From: Ben Daines [REDACTED]
Sent: 10 February 2020 11:07
To: Simon Davis <Simon.Davis@arun.gov.uk>
Cc: Chris Barker [REDACTED]
Subject: RE: BE/137/19/RES The Cottage, Shripney Road

Subject: RE: BE/137/19/RES The Cottage, Shripney Road

Drawing Title
Proposed Plans & Elevations, Plots 1-6

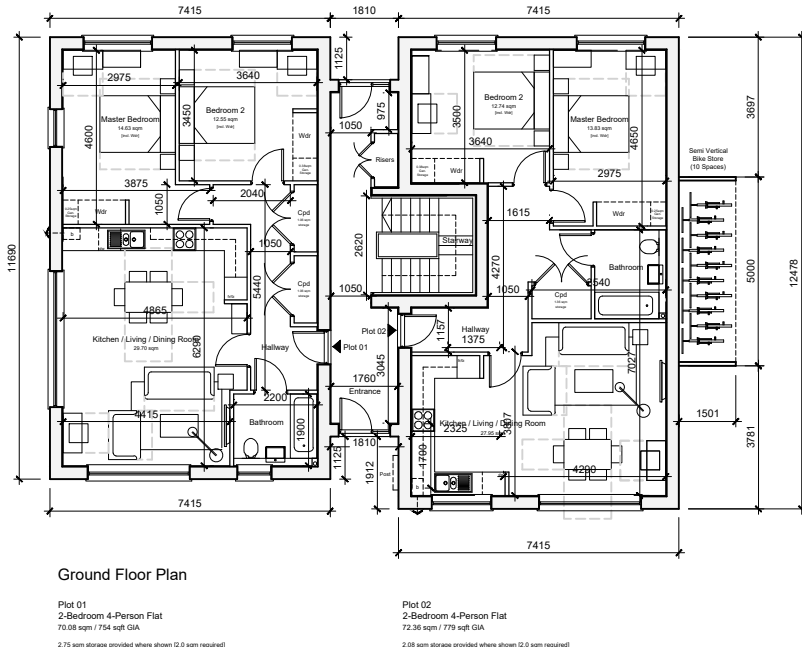
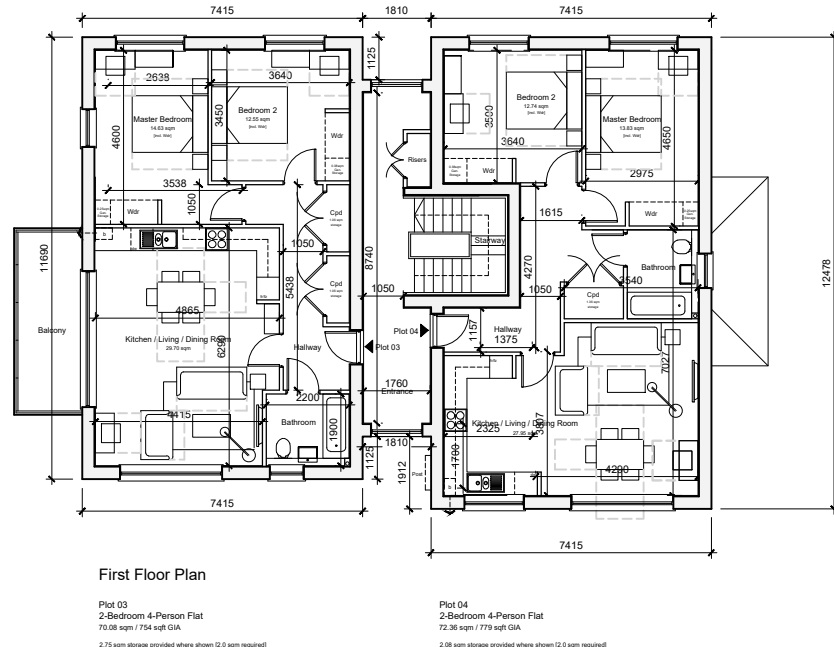
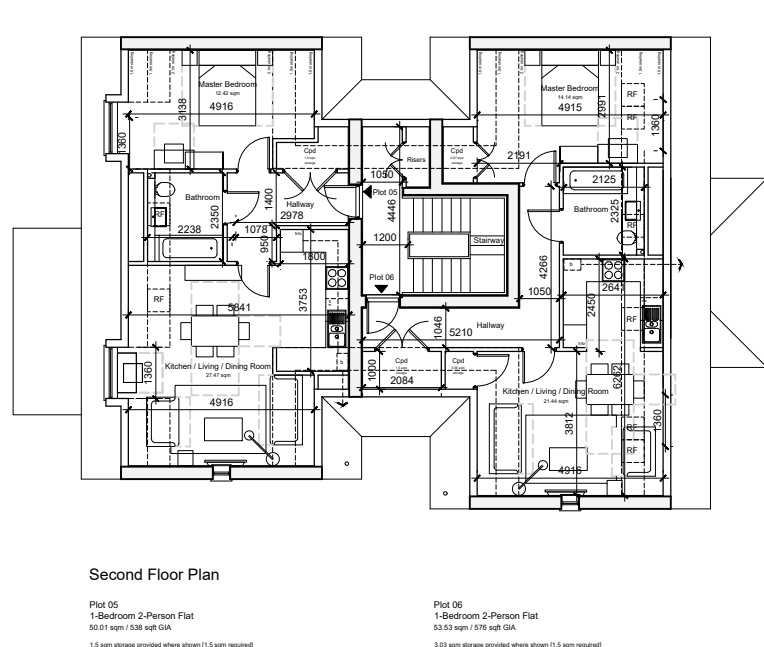
"Access & highway safety following WSCC Highways concerns that the width of the estate road is not considered wide enough making it difficult for refuse or emergency vehicles to turn safely in the development, without backing onto the A29. Arun Local Plan Policy T SP1 Transport and development. The design does not incorporate any facilities for charging electrical and plug in hybrid vehicles. Also it does not give priority to pedestrian and cycle movements and have access to high quality public transport facilities. The bus route through Shripney is every 3 to 4 hours and none on a Sunday. No consideration has been given for creating a safe cycle route along the A29 to service the development. Bersted Neighbourhood Plan Policy HDQ2 Integration of new housing. The development incorporates 2 storey dwellings these do not connect visually or integrate with the surrounding dwellings."

Design and Scale – Whilst we accept that the proposed development incorporates 2 and 2.5 storey dwellings, the original house is two-storey as are a number of other properties along Shripney Road. In fact, there are existing properties in Shripney Road that are 2.5 storeys high so we do not consider the scale of the proposed development to be out of character.
